LISMORE HOMES LIMITED

Residential Development Baldoyle GA2

Roads Infrastructure Report

SECTION 5: RESPONSES TO PLANNING AUTHORITY COMMENTS

CLIENT	LISMORE HOME LTD
PROJECT	GA2; RESIDENTIAL DEVELOPMENT BALDOYLE
DWG TITLE	Sectors 6a & 6b Basement Carparking Layout
stage	PLANNING
status	revision no.
P03	
project ref.	20003
Date	17/01/22
Drawn	R. WANI
Scale	1:1
@ A0	200

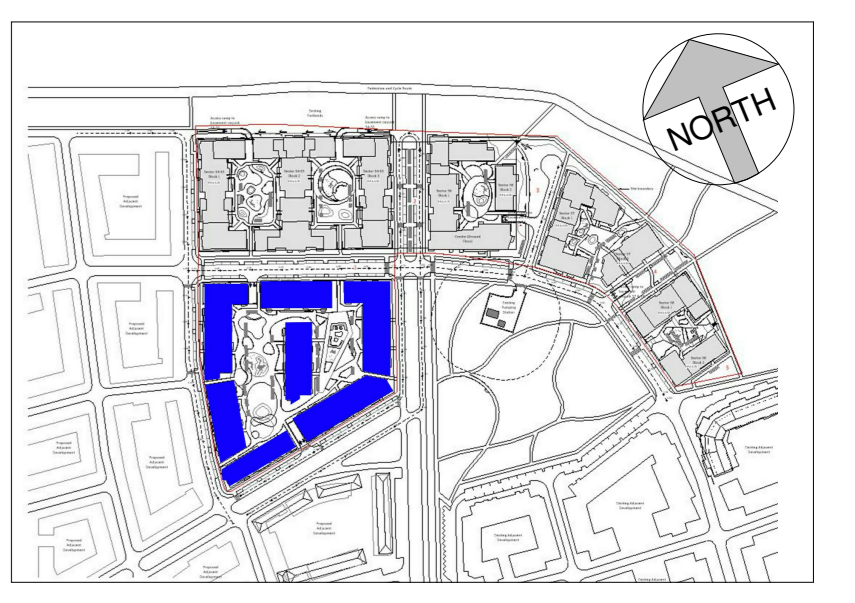
There are no details provided of the access ramps particularly with regard to the clearance heights of the ramp (particularly for cyclists if the ramp is to be shared for bicycles and vehicles), the gradient of the ramp and the provision of any transition gradients. A dimensioned drawing of the car park layout with a swept path analysis for vehicle access to restricted parking spaces and sectional views of the ramps should be provided as part of the main application;

The basement car park should be designed in accordance with the requirements of the latest version of the Design recommendations for multi-storey and underground car parks published by the IStructE. The applicant has not submitted a swept path analysis of the basement car parking areas. The design vehicle for any swept path analysis should be 5m long. This needs to be submitted as part of any application going forward.

It is the intention that all access ramps to the basement will only be for the use of cars. All bicycle parking is at ground level in secure covered enclosures. Longitudinal section drawings through the ramps are included with the application drawings. Dimensioned plans of the basement car park showing swept path analyses in restricted areas are also included with the application drawings.

The basement car parks have been designed in accordance with the current version (4th Edition) of *Design recommendations for multi-storey and underground car parks* published by the IStructE. A standard car bay length of 4.8m (for all uses) and a standard bay width of 2.4m (for mixed occupancy use) have been used as recommended in Table 4.2. Aisle widths are a minimum of 6.0m for one way traffic and 6.95m for two way traffic as recommended in Table 4.3.

Dimensioned plans of the basement car parks showing swept path analyses for a standard car are included with the planning application drawings.
